**City of Portland, Maine - Building or Use Permit Application** 389 Congress Street, 04101, Tel: (207) 874-8703, FAX: 874-8716

Proposed Project Description:  
*Finish off existing last office space in current building.*

Subject: Minor Site Plan – 70 Bishop Street

293C.004

WATERSHED MAP POST-DEVELOPEMENT

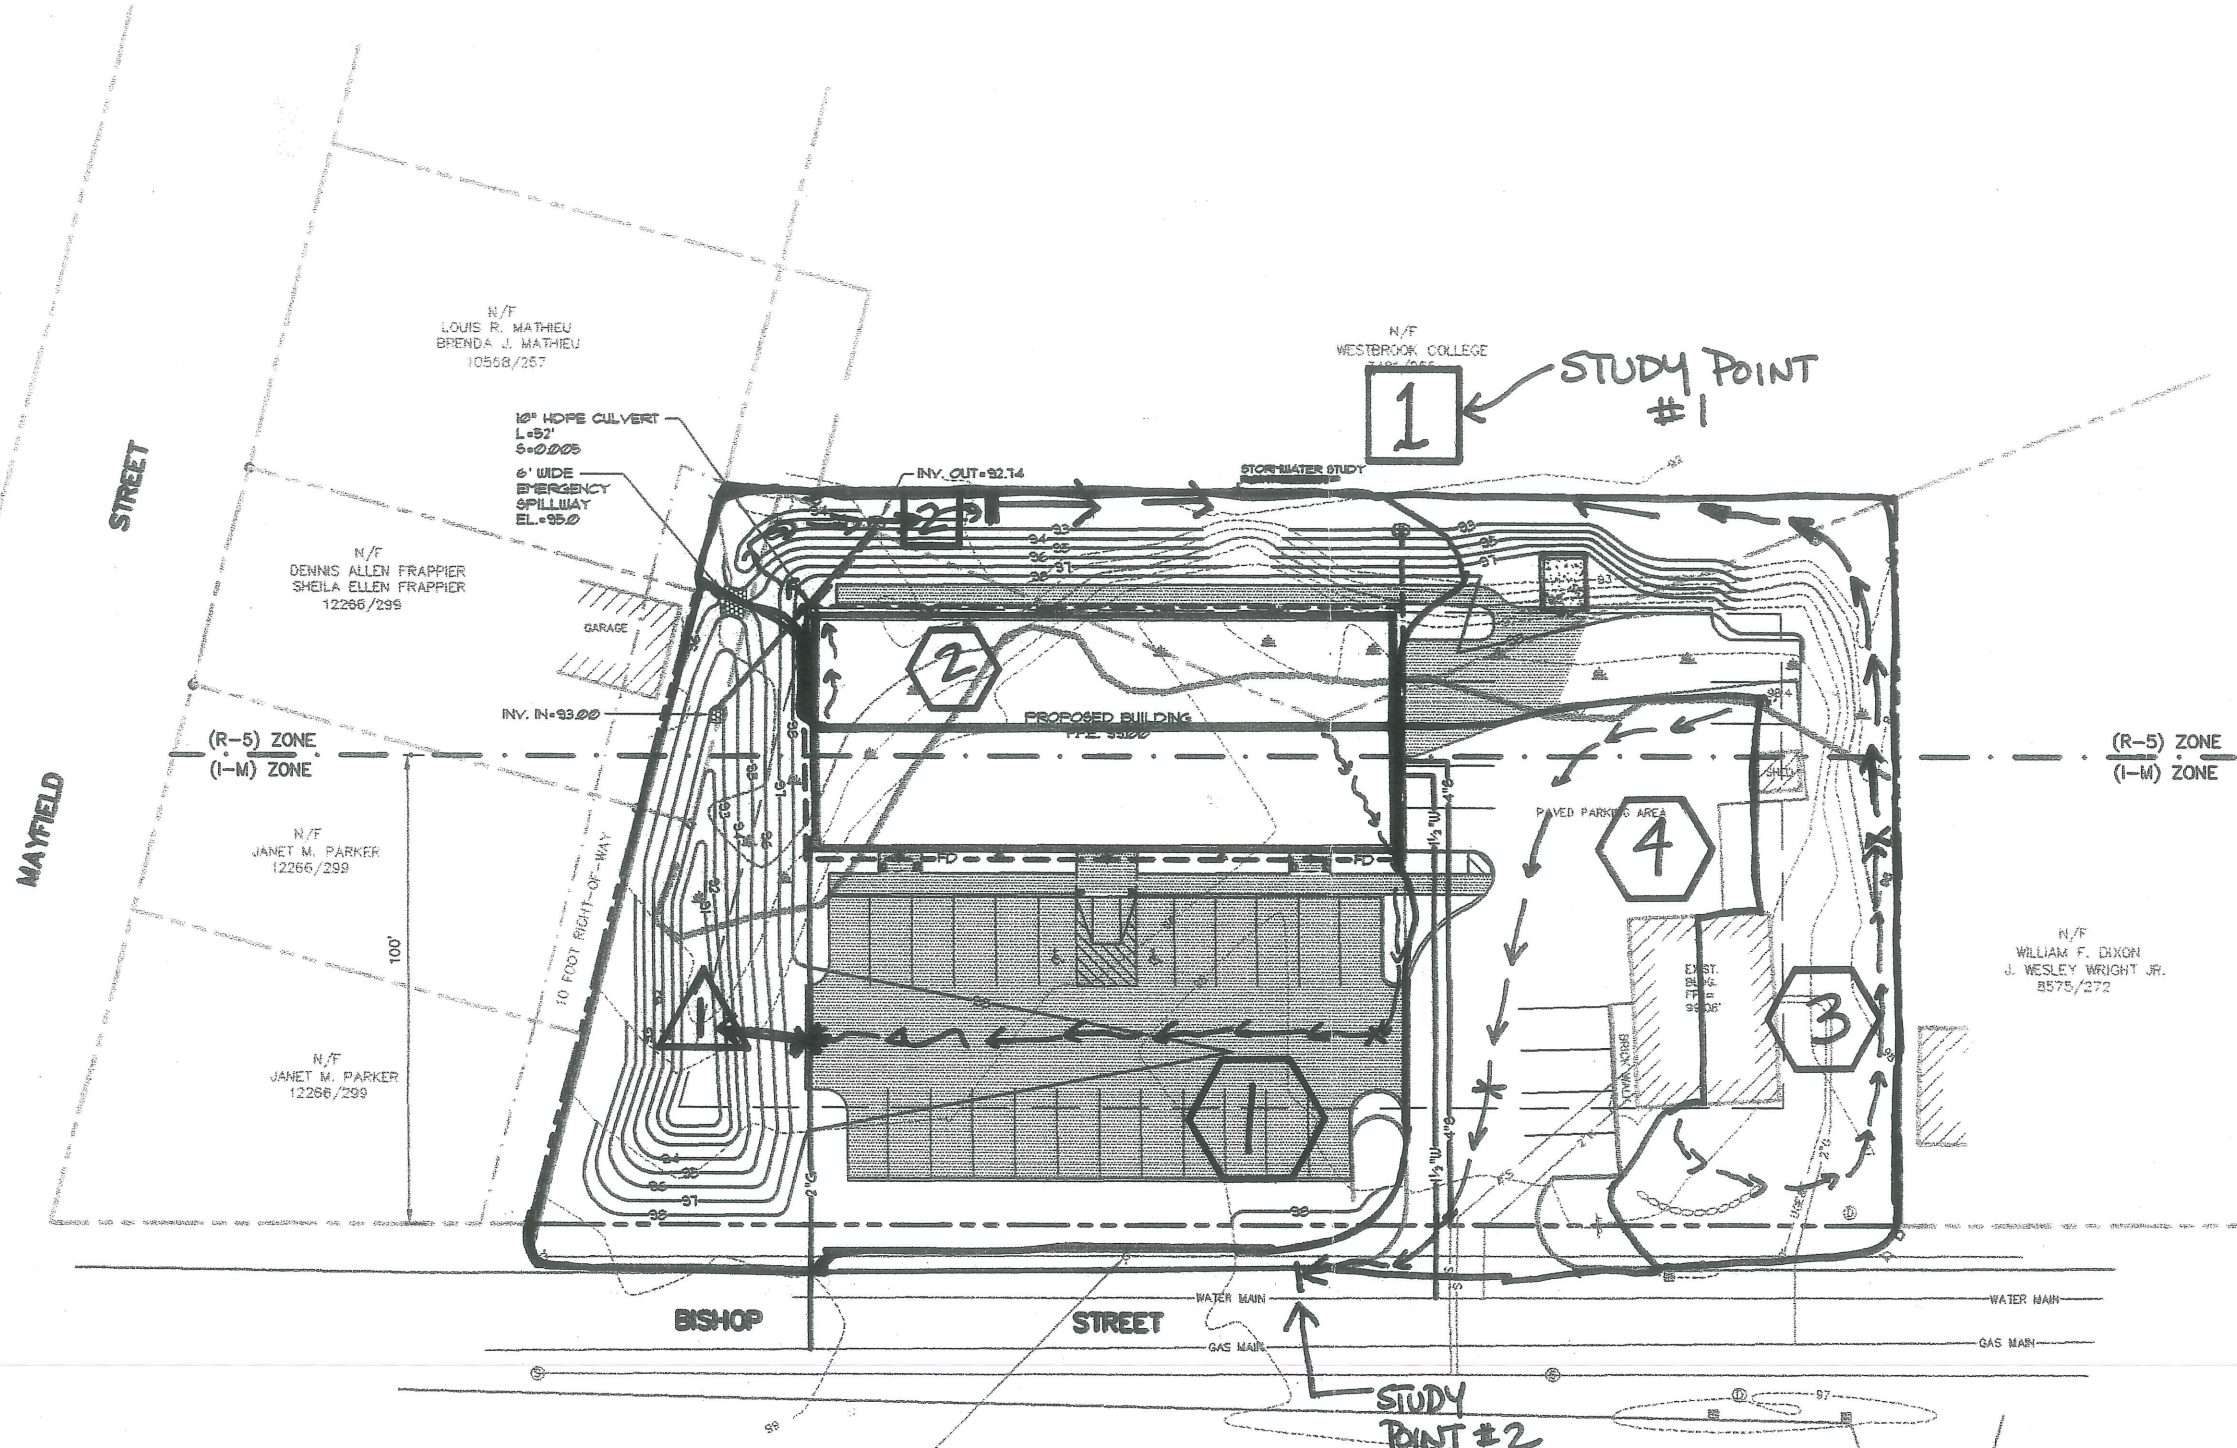
After an inspection of your site, it was found that the drainage swale/detention area was not constructed in accordance with the approved site plan.

It was noticed that, because of minor grading conditions, water is being held back on adjacent properties, and is not making its way into the drainage swale. It appears that the top of the swale is raised higher than existing ground grade. As shown on the approved site plan, the top of the swale was to be at-grade, thus designed to collect drainage from these areas.

To correct this problem, lowering the berm in a specific location along the adjacent properties would allow runoff to enter the swale.
